KIRKLEES METROPOLITAN COUNCIL INVESTMENT & REGENERATION SERVICE

DELEGATED DECISION TO DETERMINE PLANNING APPLICATIONS

Reference No:	2024/62/92915/W
Site Address:	11, Lumb Lane, Almondbury, Huddersfield, HD4 6SZ
Description:	Erection of extensions and alterations to dwelling with associated parking and landscaping and installation of roof mounted solar panels
Recommending Officer:	Molly Storer

DECISION – Conditional Full Permission

EAST ELEVATION

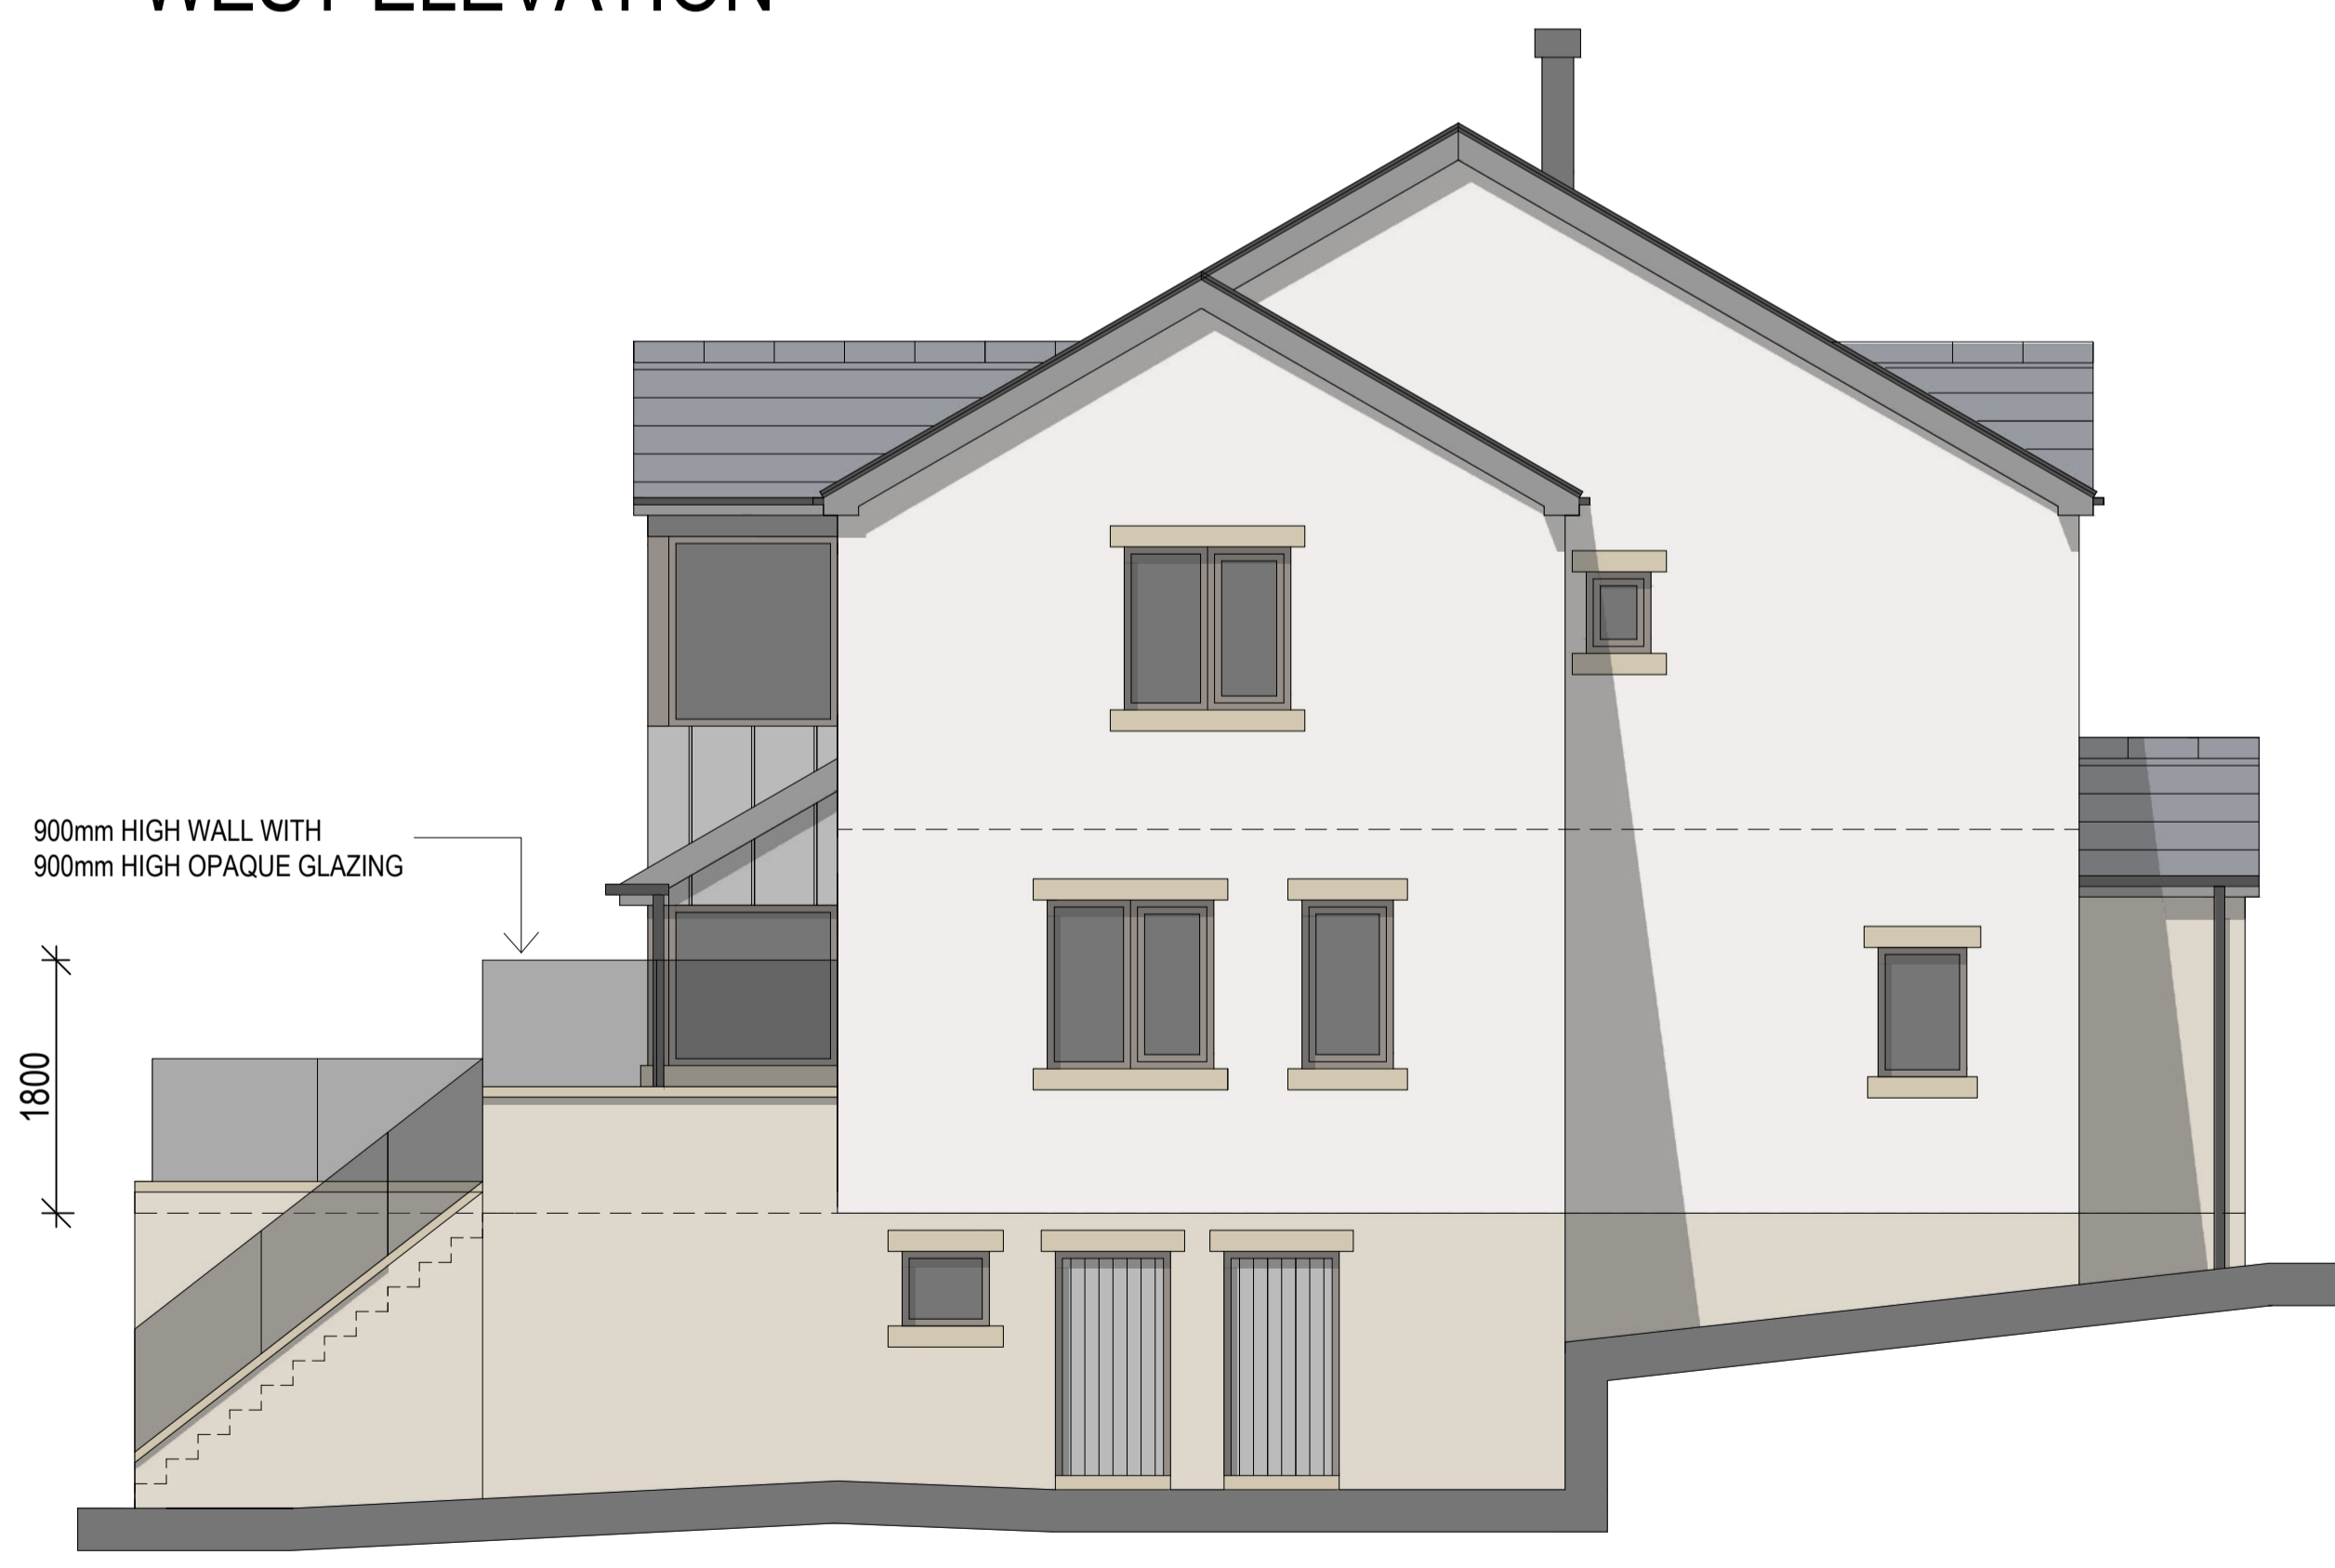
With regards to the impact on the property to the east (No.9 Lumb Lane), initial concerns were raised that the rear terrace could result in overlooking due to only having a 0.9m screen with opaque glazing situated 3.1m from the boundary. However, a condition will be attached to any grant of permission which states a 1.8m privacy screen must be placed on this boundary to prevent privacy impacts.

3. The raised terrace shall not be brought into use until a 1.8 metre obscurely glazed screen (to a minimum privacy level of Grade 4 or equivalent) or timber fencing or metal balustrade to a height of 1.8m high has been constructed on the east elevation of the raised terrace. The obscure glazed screen or timber fencing or metal balustrade shall thereafter be retained.
